Town & Country Planning Act 1990 (as amended)
Town and Country Planning (Development Management Procedure) (England) Order 2015
Approval of details reserved by condition imposed under CM/26/18/L relating to Condition No 3
northern gable and Condition No 4 schedule of materials and samples.
Clymping Mill Clymping Street, Clymping,

Arun District Council have decided to **APPROVE IN PART details reserved by condition**

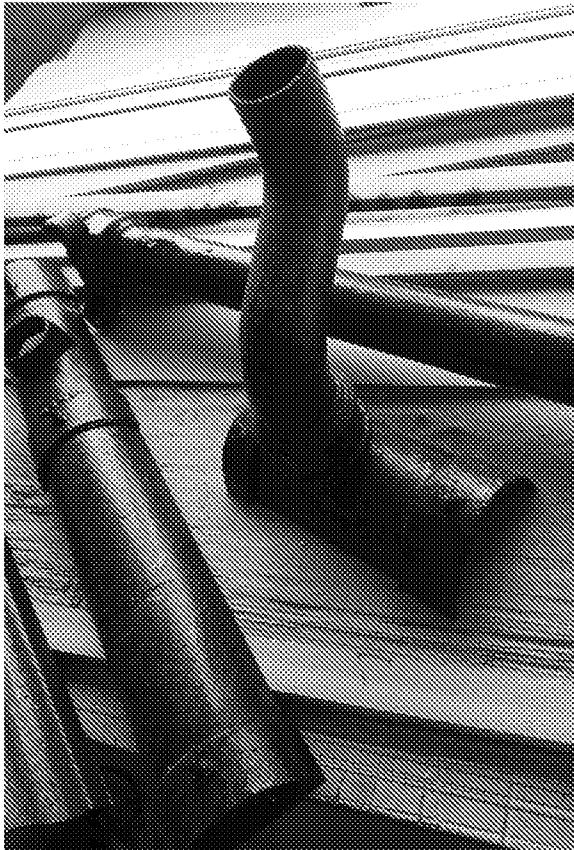
This condition is partly discharged in so far as submission of details relates and refers to the submitted clay tile details (which are the same as those used on Mill Cottage) and refurbished cast iron rainwater goods.
